Submission on Modification to Vincentia District Town Centre - Stage 1 - MP  
06\_0025 MOD 5

The Vincentia Ratepayers and Residents Association is the council-recognised community consultative body for the Vincentia District Centre (VDC) project location.

Sheet No. 1 of 16

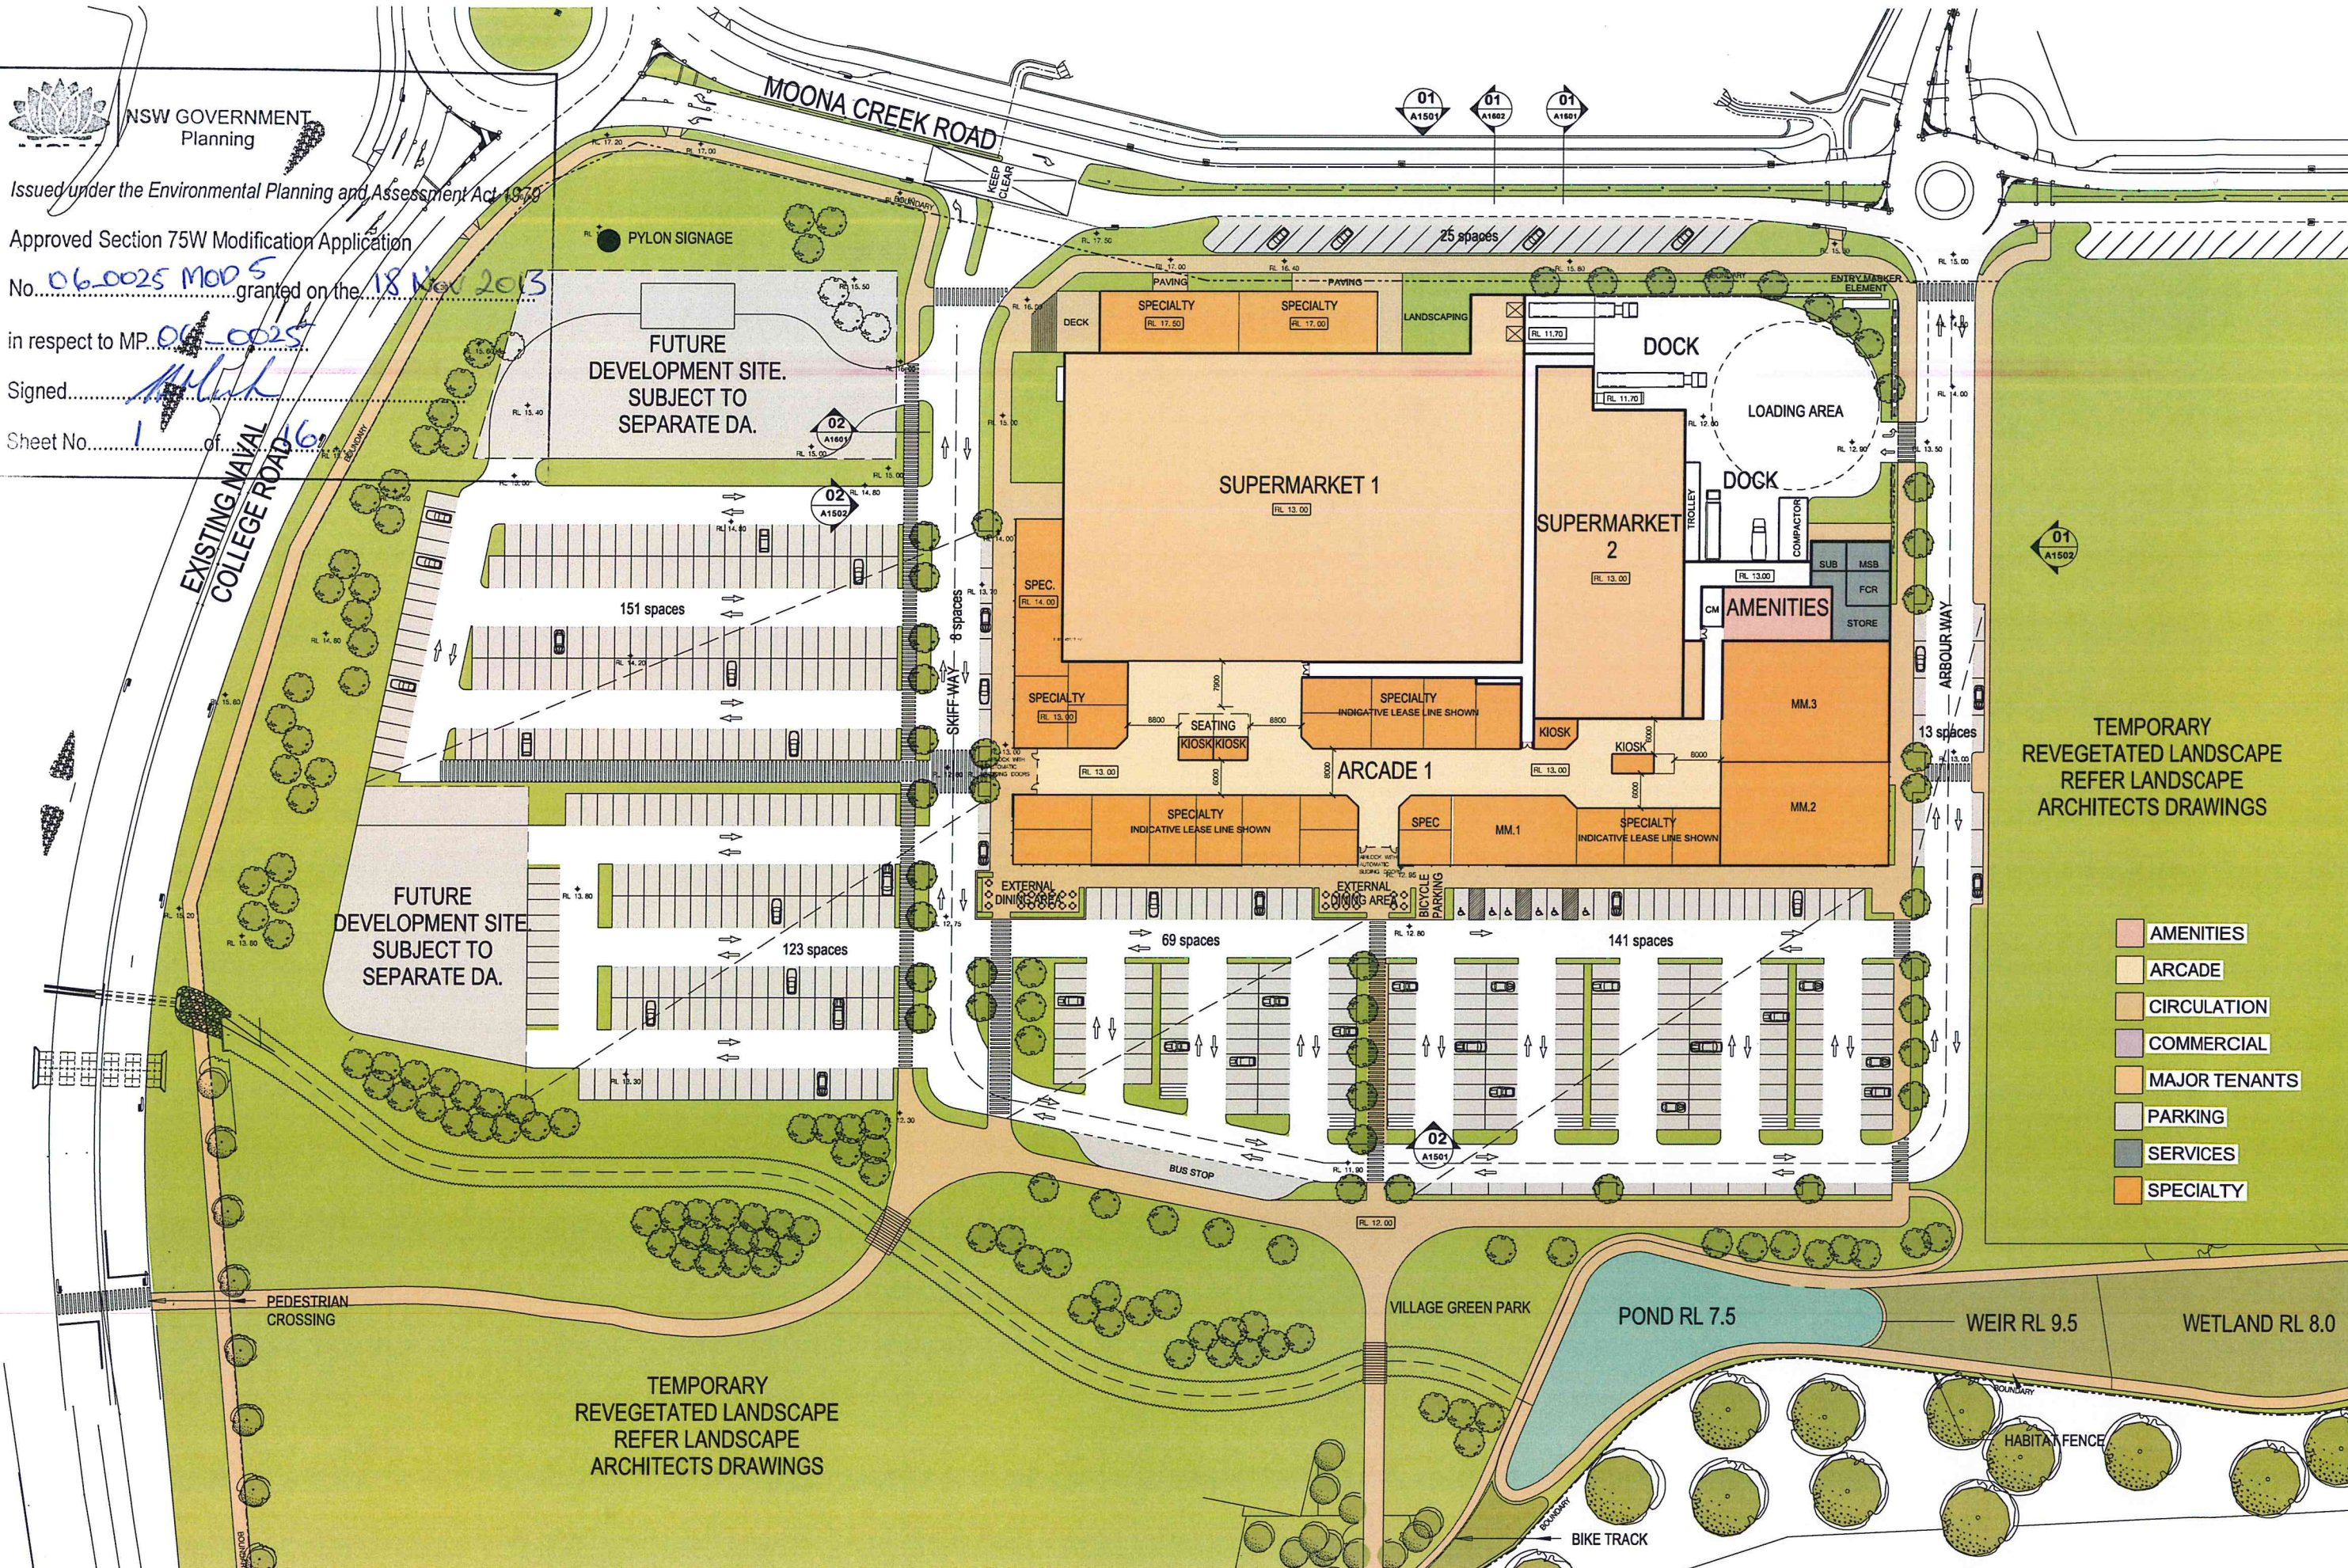
The quasi-public space of Arbour Walk has been diminished by removing almost all commercial activity. It has now been reduced to little more than a desolate mall entrance bounded by a loading dock and services. It is referred to as “The Meeting Place” in the proponent’s “placemaking strategy” and is illustrated with tables, chairs and umbrellas. However, there is little reason for people to use this space due to the lack of commercial or retail frontage and the relatively small percentage of patrons accessing from the Bayswood development. The “vistas” referred to in the “proposed connectivity” are now interrupted by a covered air-lock and carpark. This is a long way from the original concept of a public domain. Suggesting that “the maintenance of key sightlines to the site’s natural surrounds are all maintained by the proposed modifications” ignores that the sightlines are now through carparks.

In this modified plan, the Village Green is shown located in a variety of positions. The “placemaking strategy” indicates it positioned as part of Arbour Walk, sandwiched between 2 sections of carpark. The Phasing Plan (Appendix A) shows it to be at the back of a carpark and behind the bulky goods precinct. Both are equally dysfunctional and not conducive to a vibrant community space.

Community facilities including a district library, medical centre and childcare centre were all included in initial designs. The aspiration for a library in particular is a reason that many initially supported this project. The library is now the only remaining non-retail facility. It has also been shifted from being a focal point of the centre to being an appendage to a bulky goods precinct.

In addition, the library floorspace shown on the plan has been dramatically reduced from 1100m<sup>2</sup> to 690m<sup>2</sup>.

Provision for disabled car parking is inadequate. The region has a skewed age population distribution that requires a greater than average provision for disabled parking.

The extensive carpark shows almost no vegetation, creating a stark landscape with little connection to the original and surrounding bushland. Whilst it may be easier for the proponent to build and maintain a fully paved car park, this is at odds with the community's aspiration for a precinct that is both functional and visually appealing.

1 ELEVATION
WEST ELEVATION - MOONA CREEK ROAD

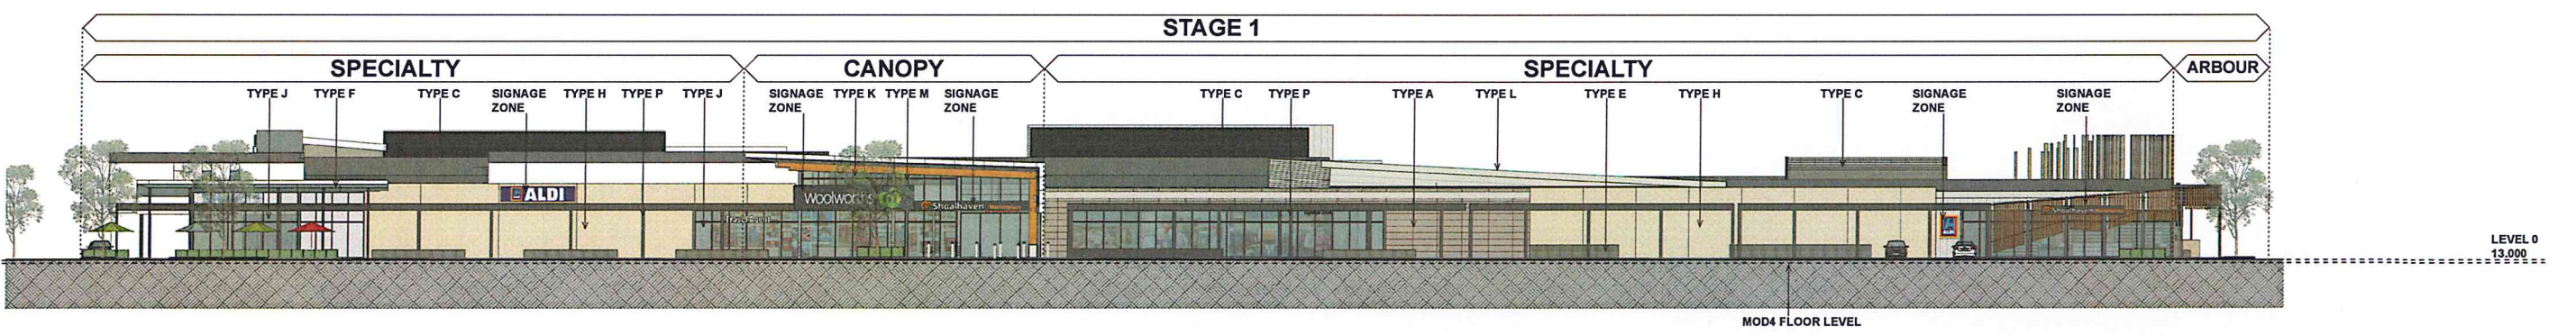
Rice Daubney won the design competition having modified the concept of a “main street” such that Moona Creek Road became the main street through the placement of commercial activity to activate that zone.

The proponents have now ignored the concept by removing all commercial activity from Moona Creek Rd. All activity has been absorbed internally, resulting in little more than a generic mall surrounded by carpark. This does nothing to respond to the special environment in which the development is located.
